## Planning Application - Anglian Water Response

<b>Anglian Water site reference:</b>	PLN-0237550
<b>Response date:</b>	29 January 2026
<b>Local Planning Authority:</b>	South Holland
<b>Planning application reference:</b>	H16-1191-25
<b>Site address:</b>	39-41 Albert Street Spalding PE11 2LD
<b>Proposal description:</b>	Demolition of redundant commercial buildings and the erection of 5 dwellings

Drawing Planning (Plots 4 & 5)

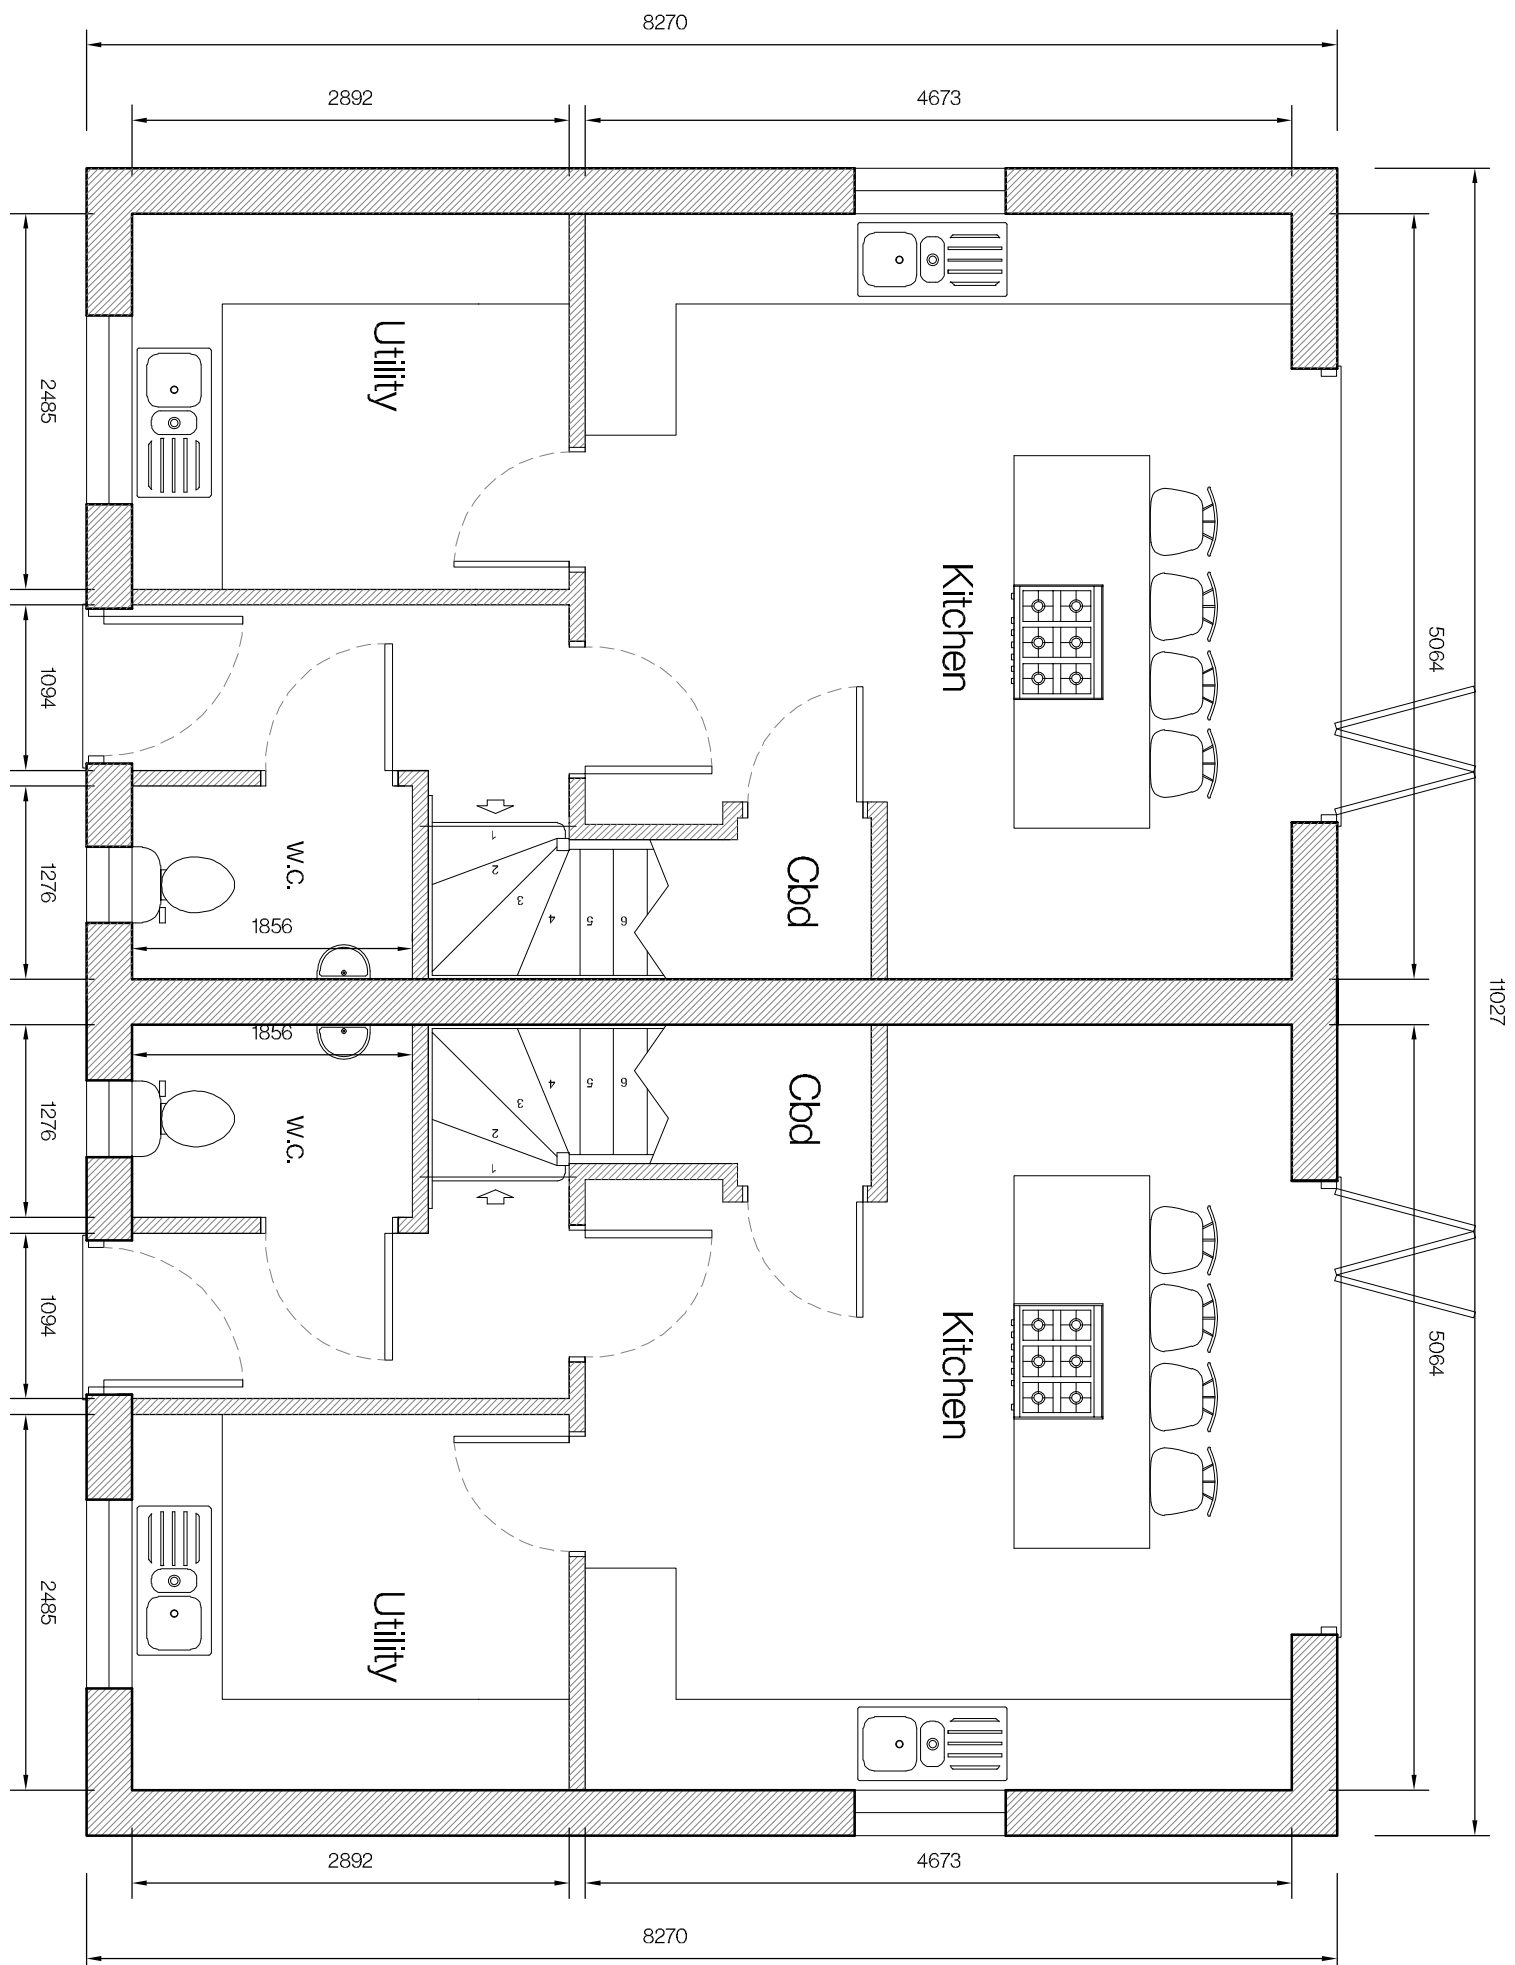
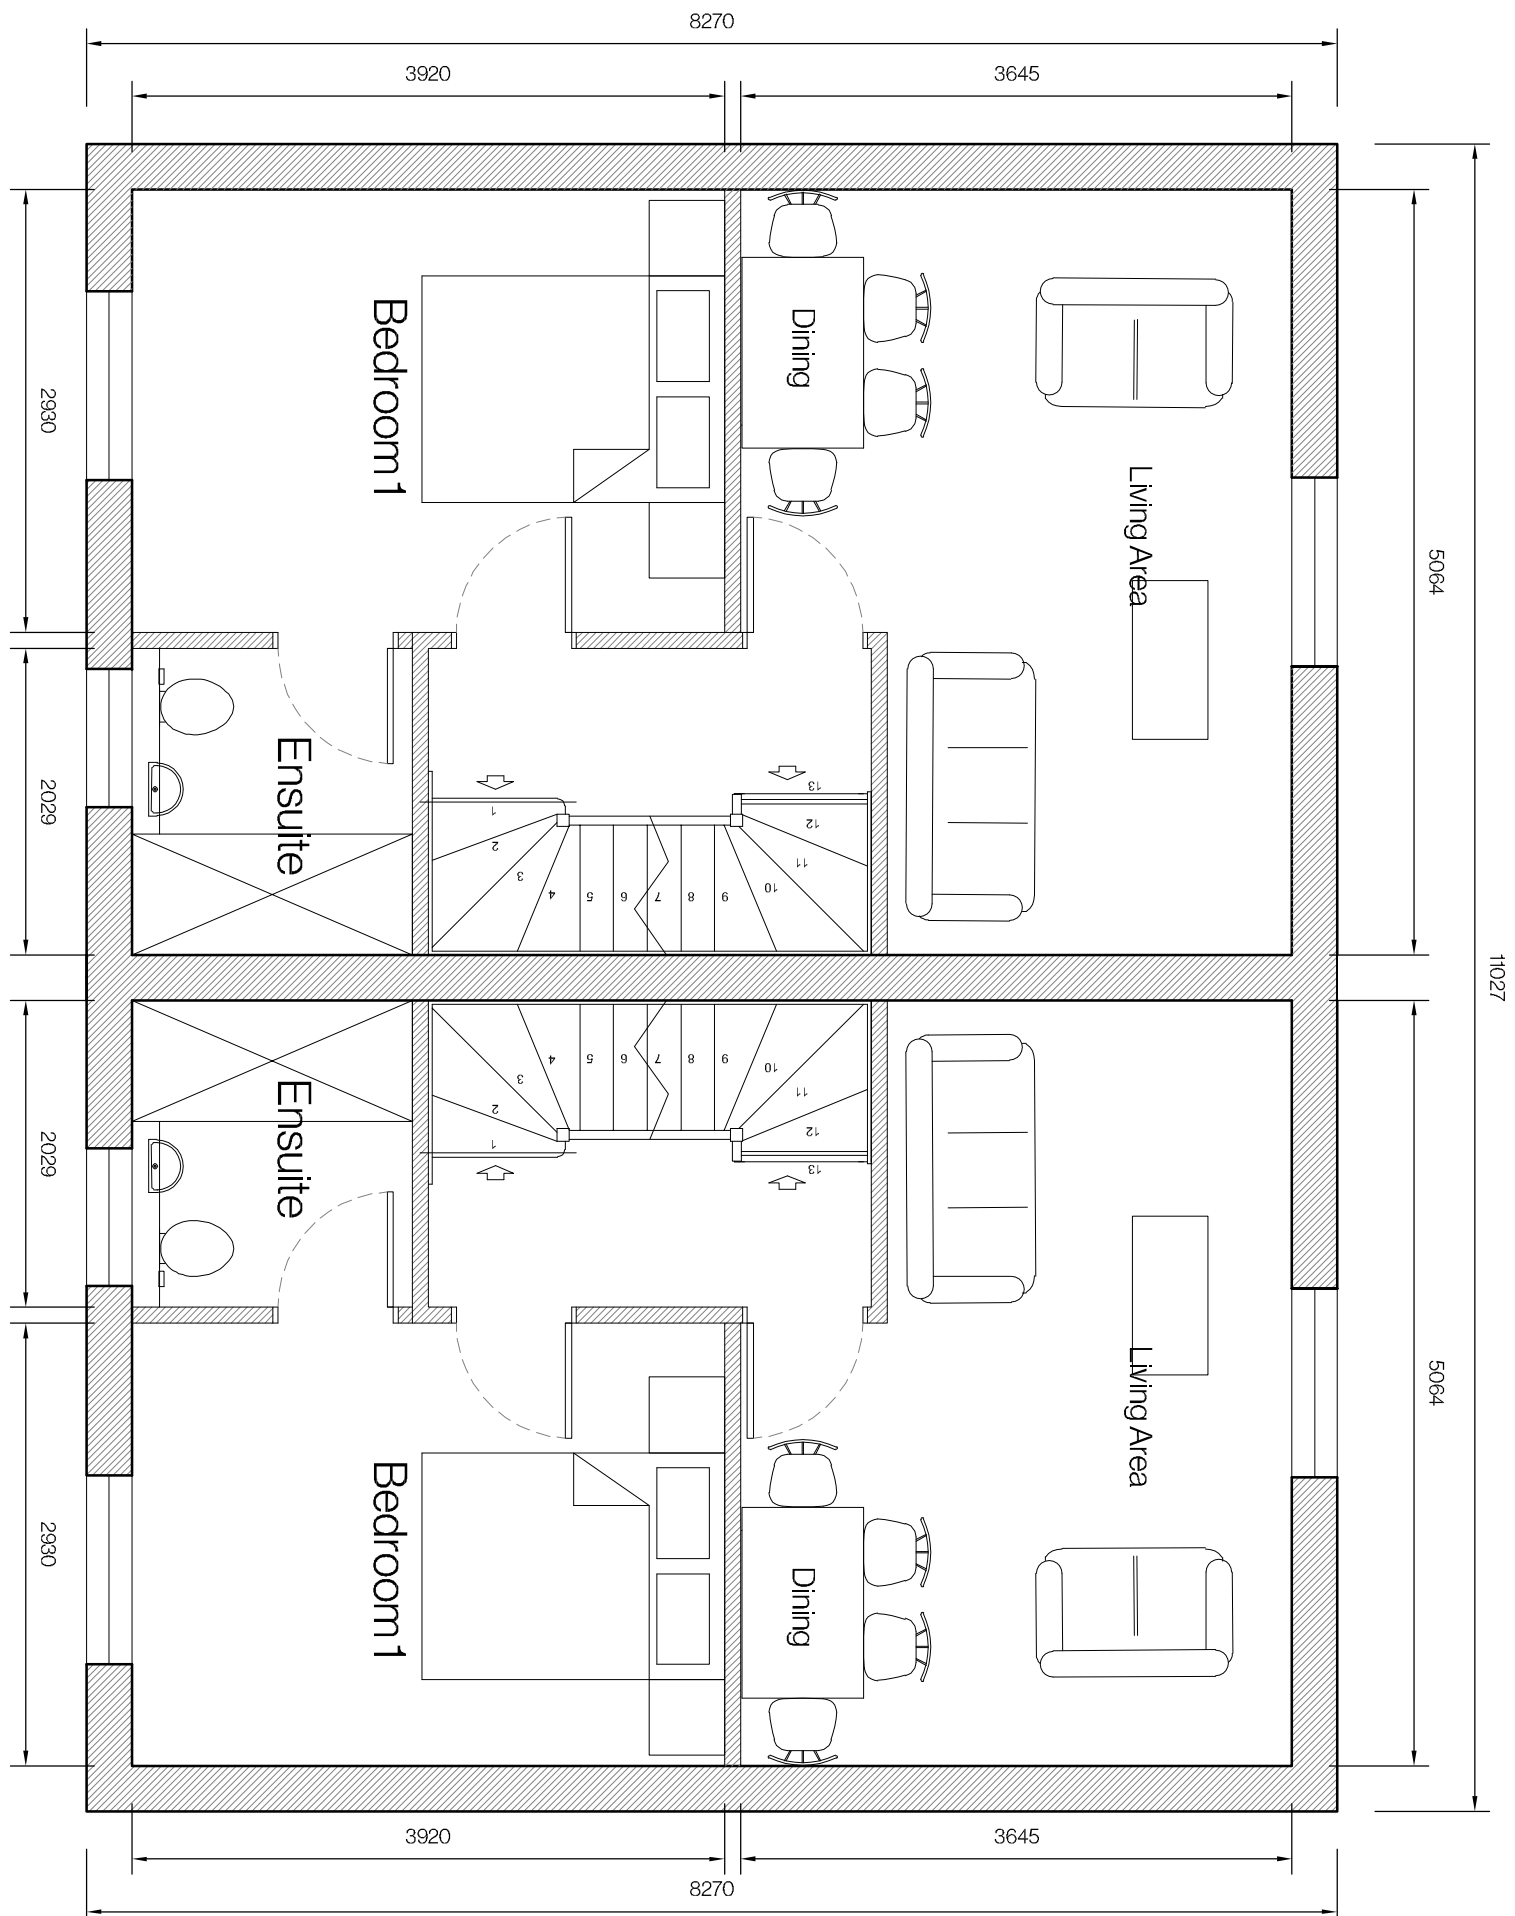
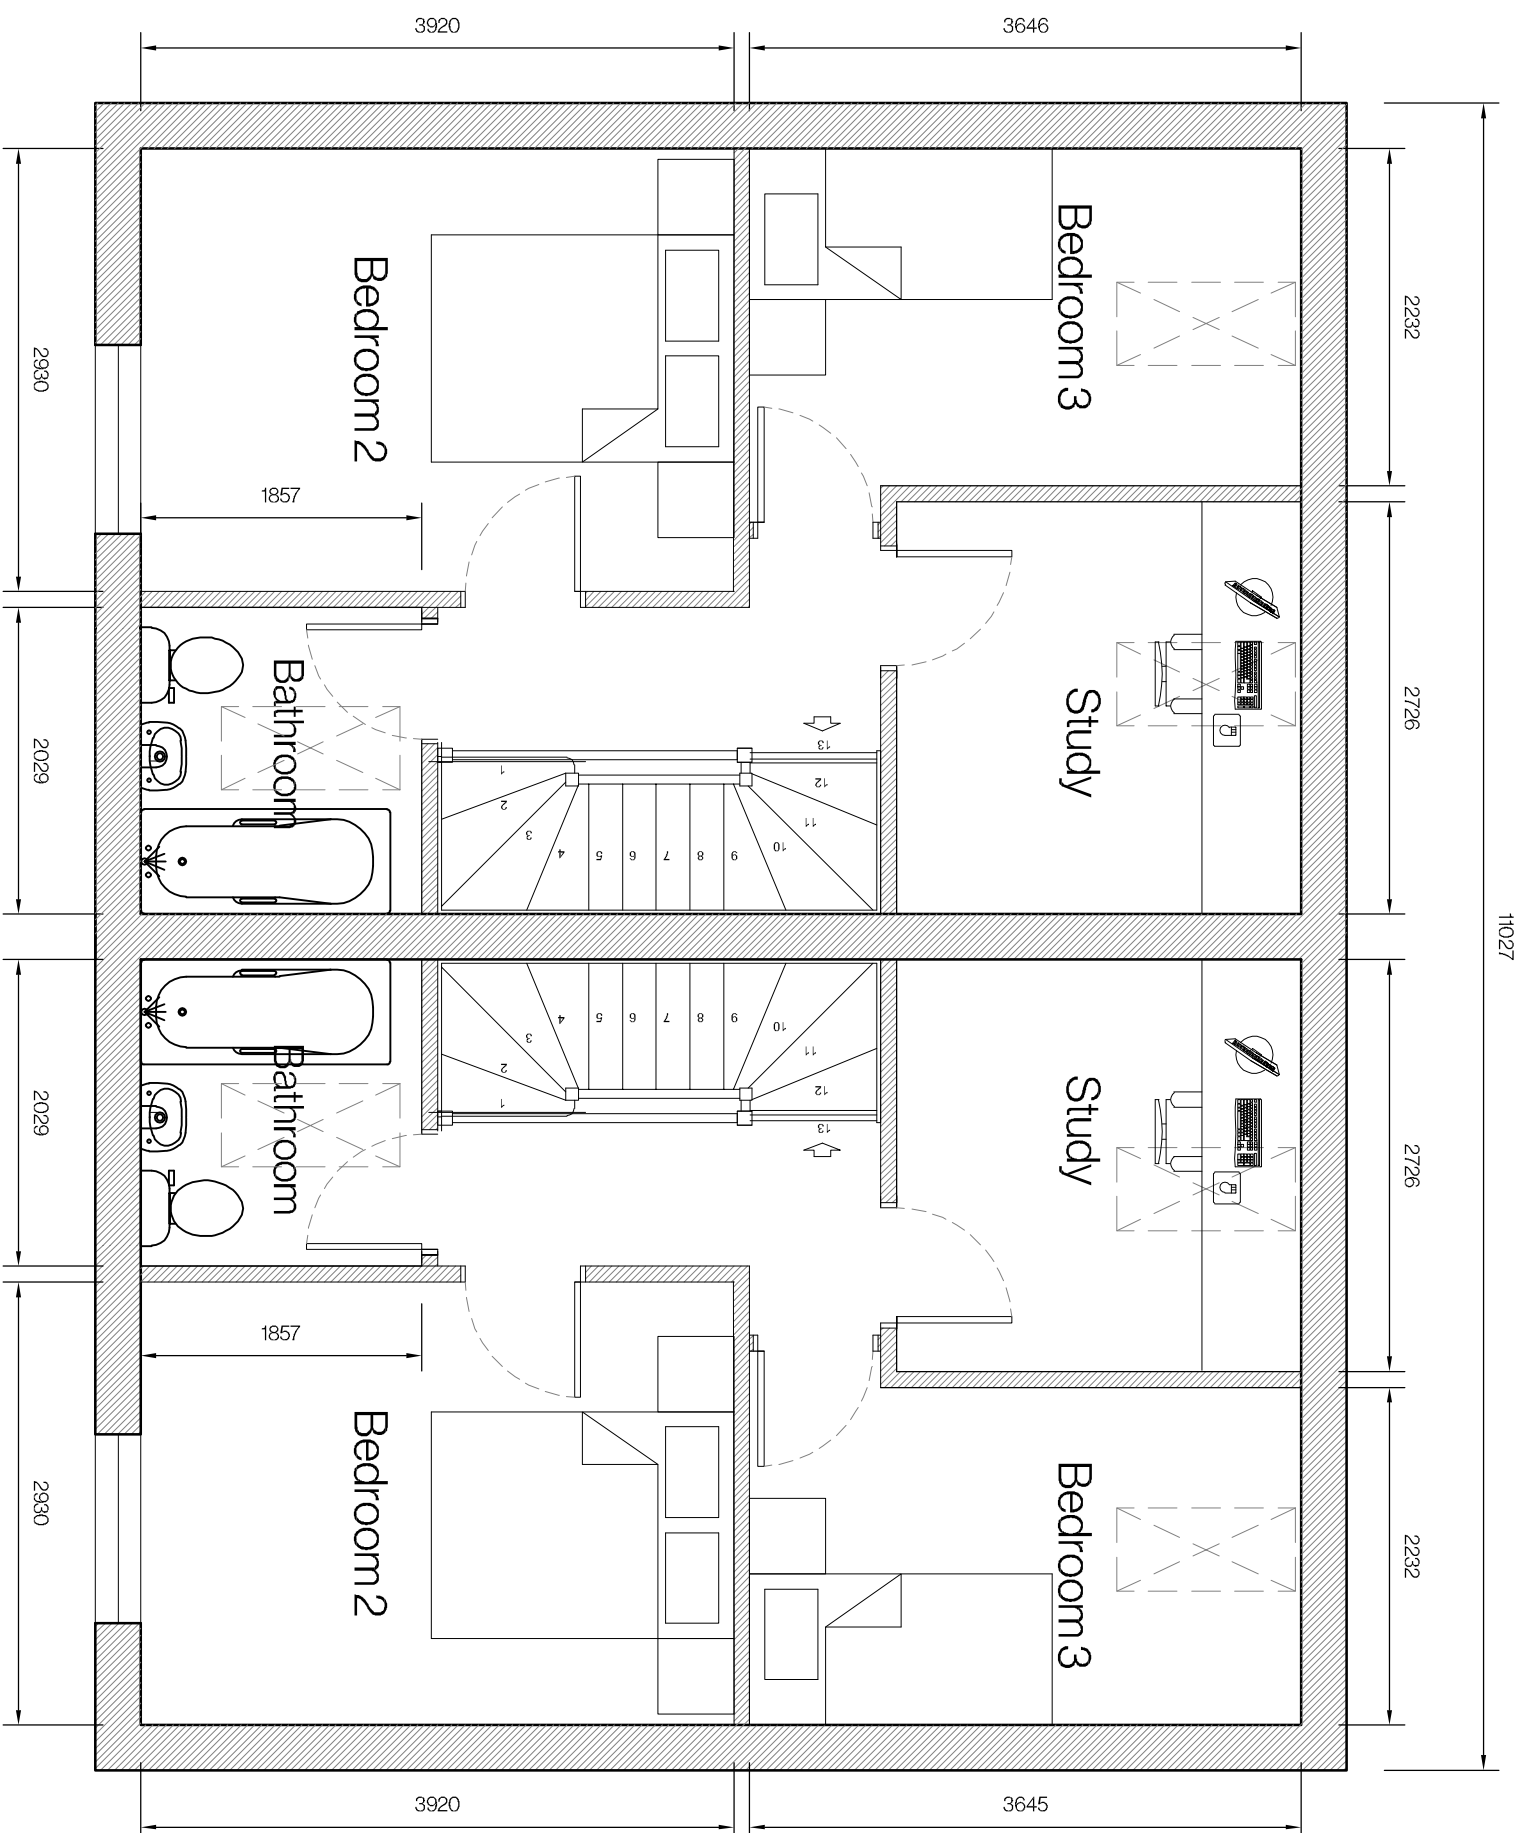
We need to inform you that there is a 225mm foul sewer, 250mm foul rising main and 3inch water main which are close to or crossing the site and are affected by the proposed development. We have reviewed the submitted development layout plan and we can see that Plot 5 is affected by the above Anglian Water owned assets.

Anglian Water acknowledge the existing building already close to or over our asset. Nevertheless, for new development Anglian Water does not permit these assets to be located within the curtilage of the proposed building. These assets should be located in areas of public open space and/or adoptable highways to ensure on-going maintenance and access is possible. The site layout plan, as submitted, indicates that the above assets may be located within the curtilage of a building. We strongly recommend that the applicant reviews the site layout plan and takes the above in consideration to reflect the easement required for the sewer which is 3 metres both side of the sewers, and 4.5 metres overall for the water main.
